25 July 2018

**RE: Exhibition of Modification Request for the Northside Mental Health Facility, 2 Frederick St (previously known as 10 Herbert St), St Leonards (SSD 7588 MOD 2)**

**Re: No 4 Frederick Street, St Leonards - Northside Mental Health Facility  
(your ref: SSD – 7588) (10 Herbert Street St Leonards - Lot 2 DP 12112720)**

## **SUBMISSION - PROPOSAL FOR NORTHSIDE MENTAL HEALTH FACILITY (YOUR REF: SSD – 7588)**

PSY140494-StormwaterManagement-GroundFloor-C2.01-16.12.15.dwg

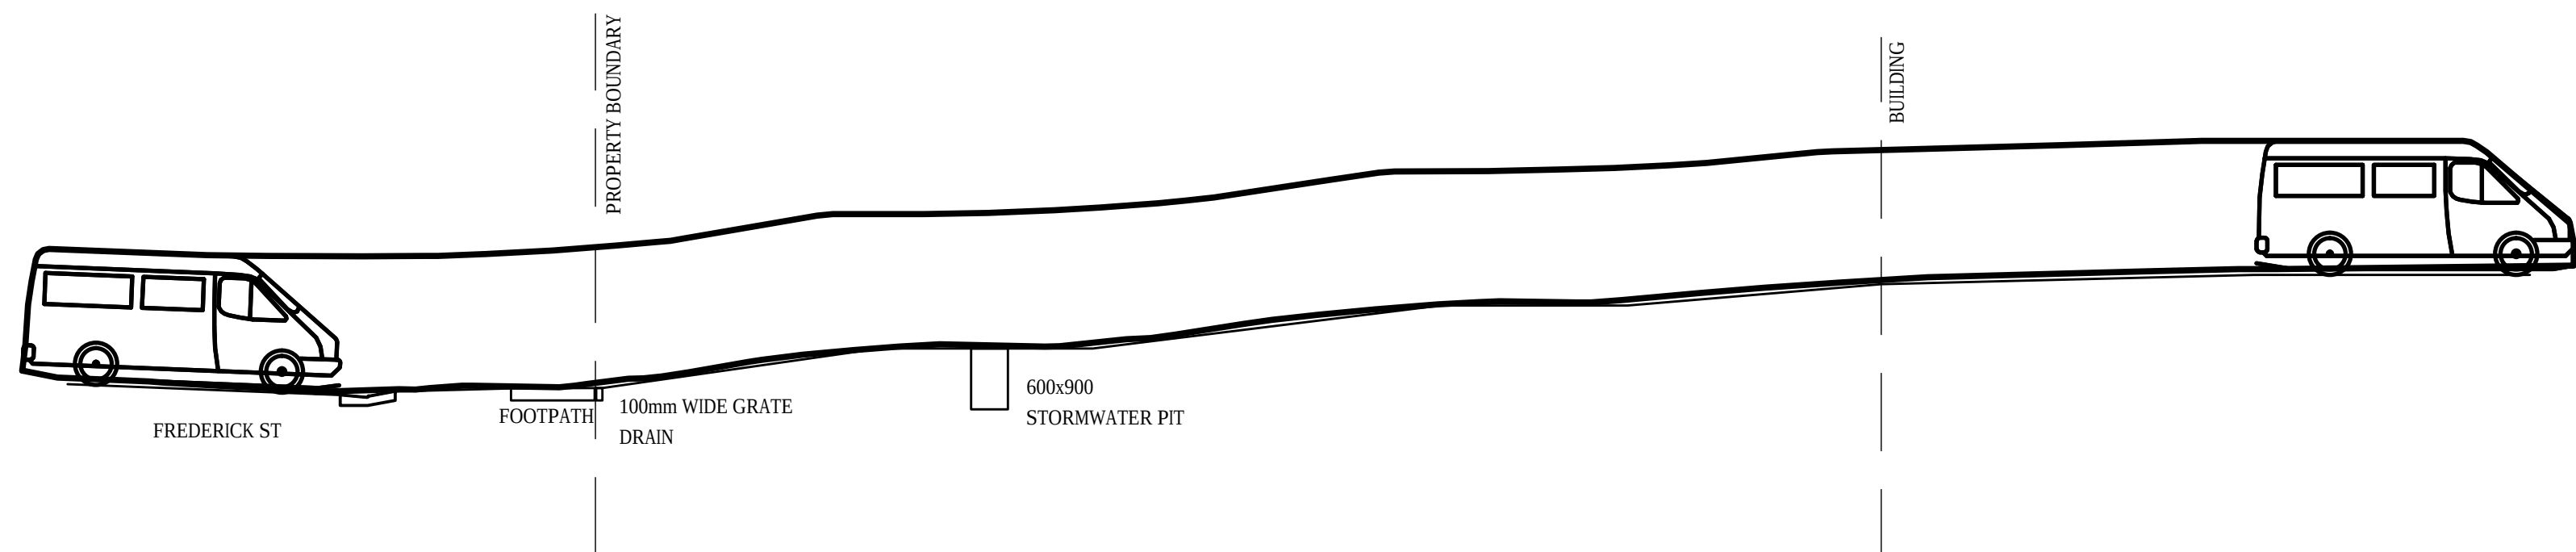
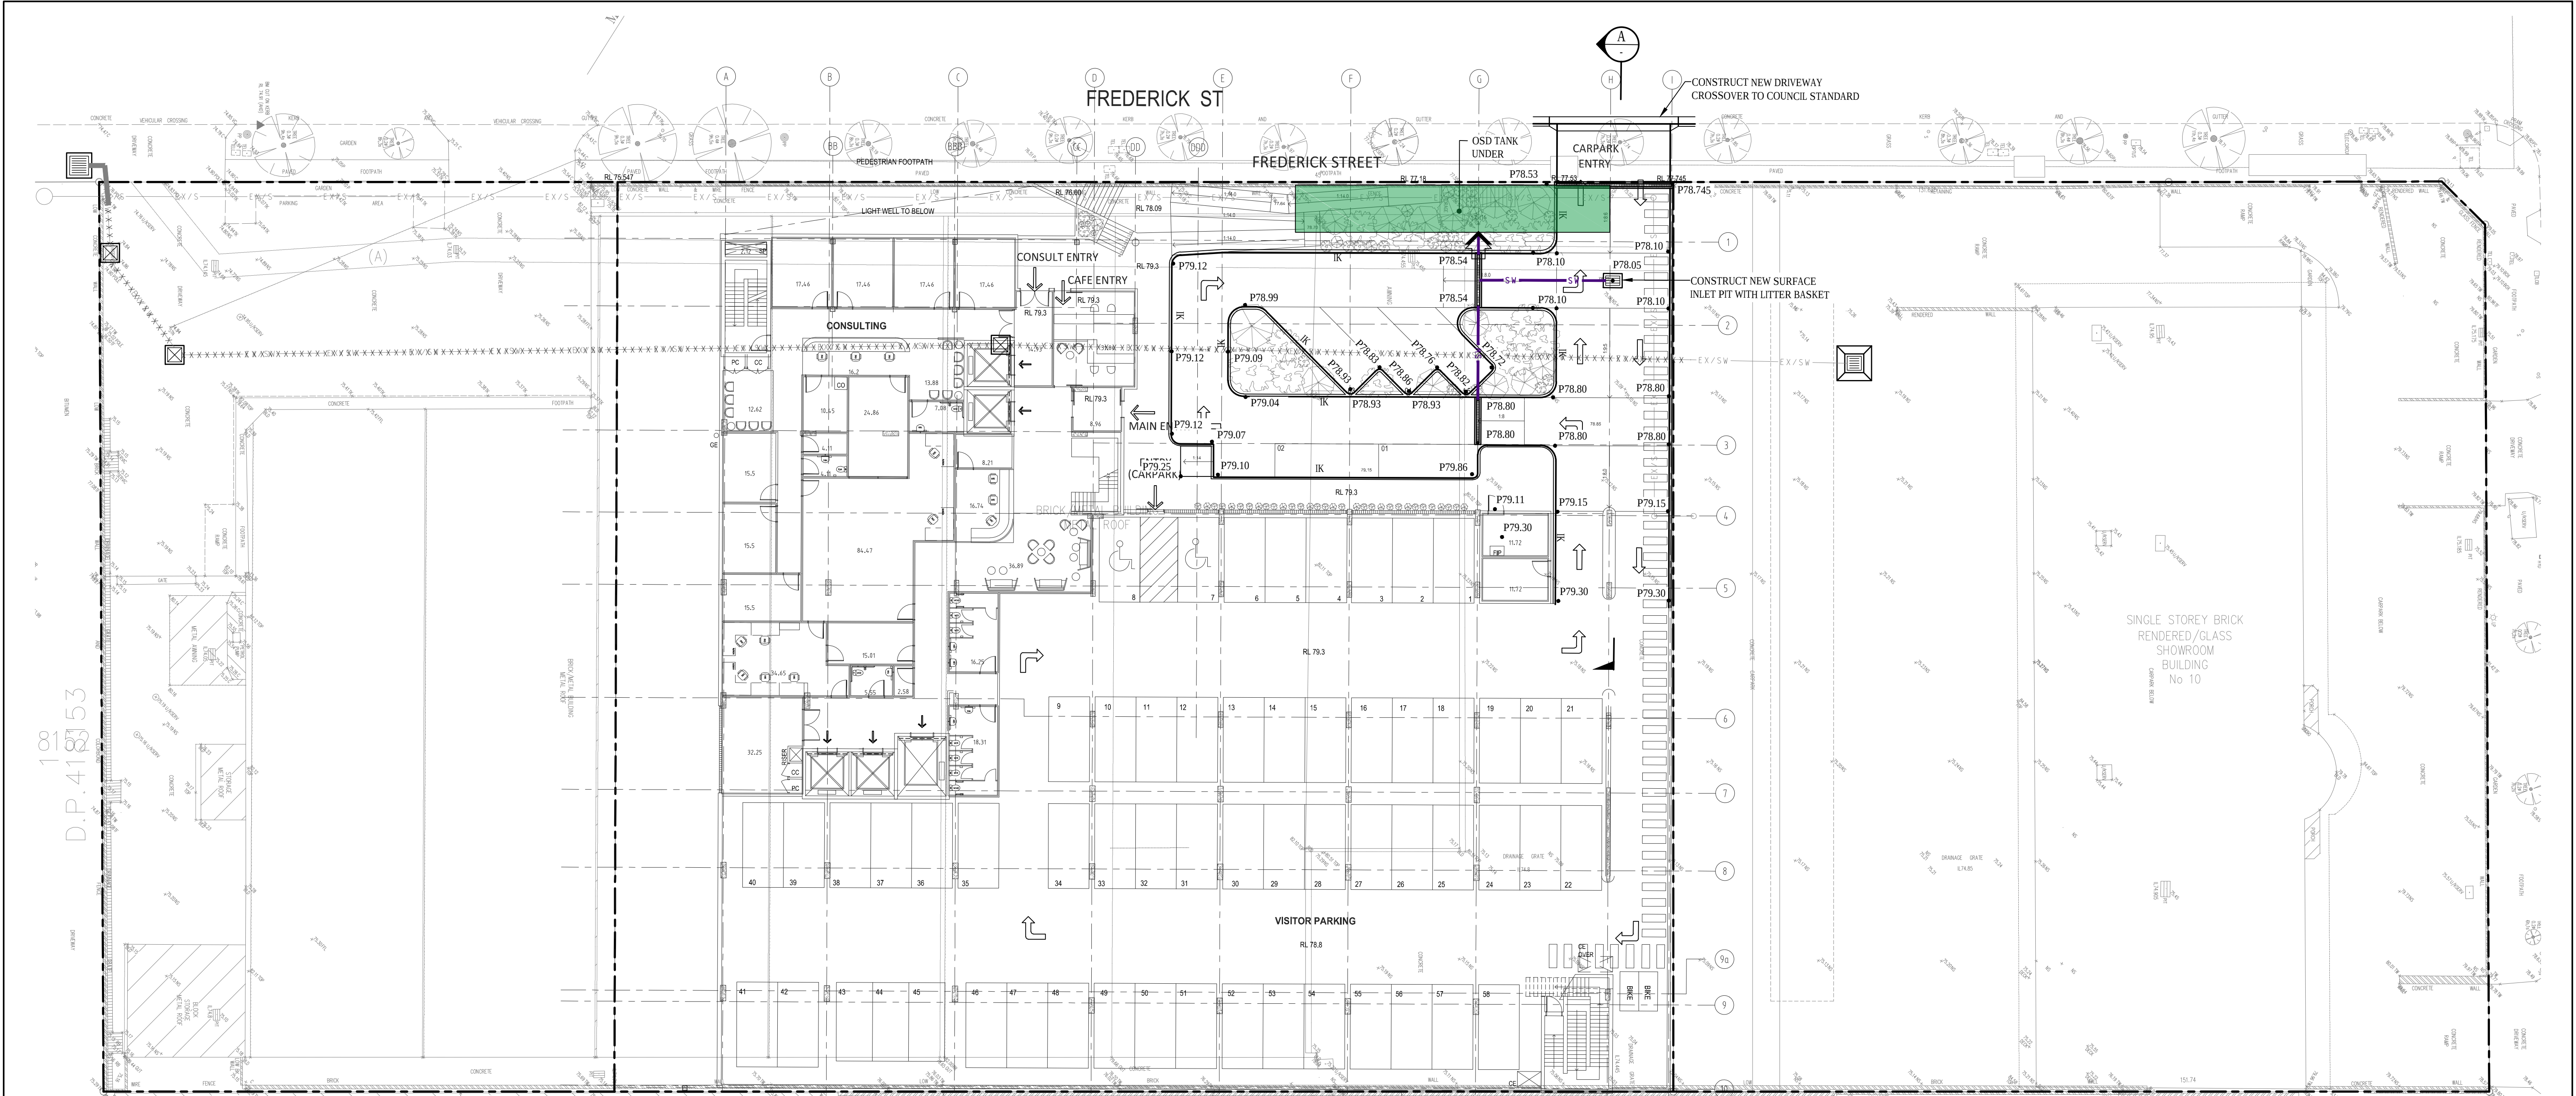
The stormwater management plans submitted with the SSD are considered inadequate and inaccurate in their current form. The stormwater drainage management plan should be redesigned in order to allow the overflow of the proposed on site detention system to be discharged to Frederick Street without causing any extra runoff to downstream properties as there is no underground pipe system fronting the proposed development.
